Our Ref: 2025/680840
File No: R/2016/41/K
R/2022/25/D
R/2023/8/L

SSD-7874 – Mod-6 (Harbourside Concept)
SSD-49295711– Mod-8 (Podium and Tower)
SSD-49653211– Mod-1 (Public Domain)

The applications seek to modify the relevant development consents to permit the removal of the northern bridge from the development, currently required to be reinstated, and modifications to the podium to relocate the public lift.

Figure 5 | Indicative intersection configuration. (Source: JMT Consulting).

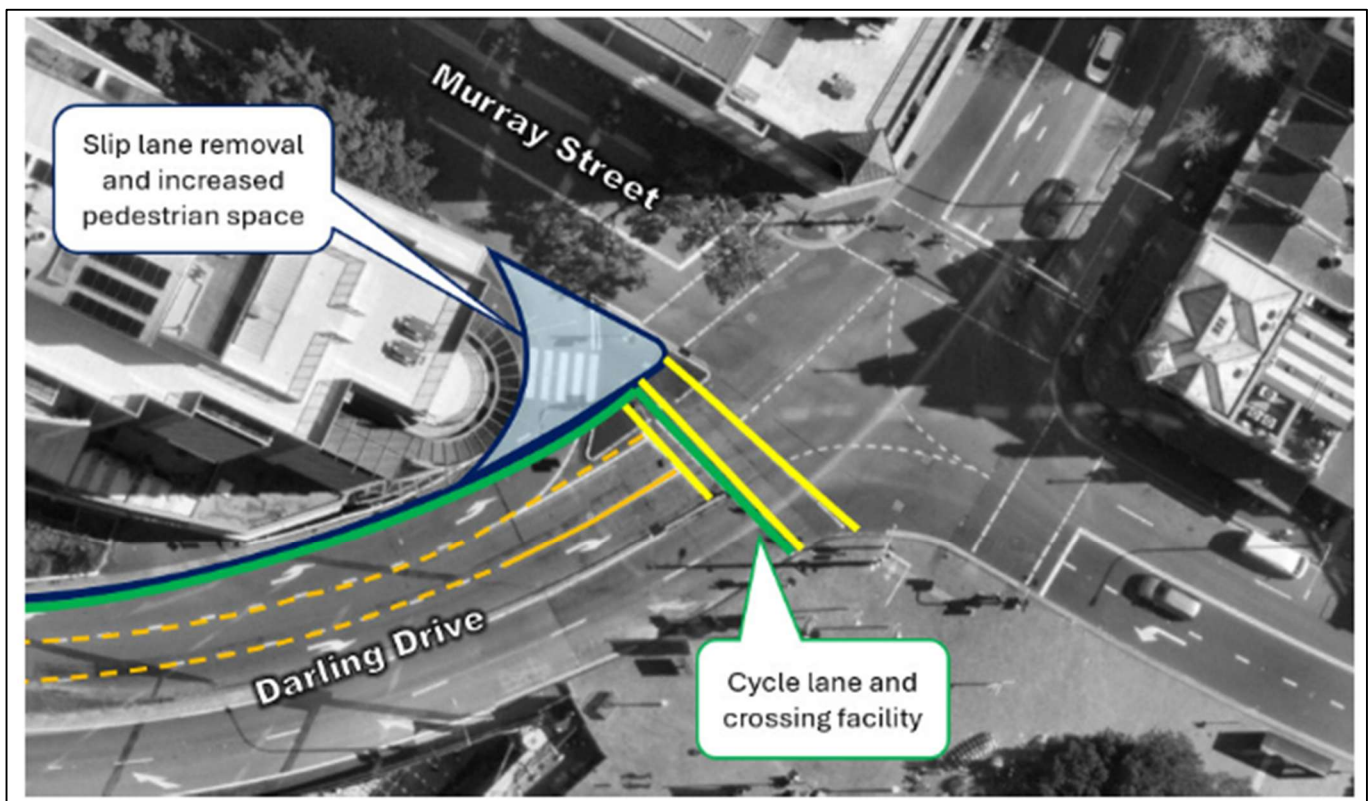
The proposed realignment of the Darling Drive cycleway creates a potential conflict for cyclist and vehicles. Cyclists will appear to turn left towards Murray Street out of view before needing to cut back across the slip lane to the pedestrian island. It is suggested that this arrangement be reviewed to prioritise cyclist safety.
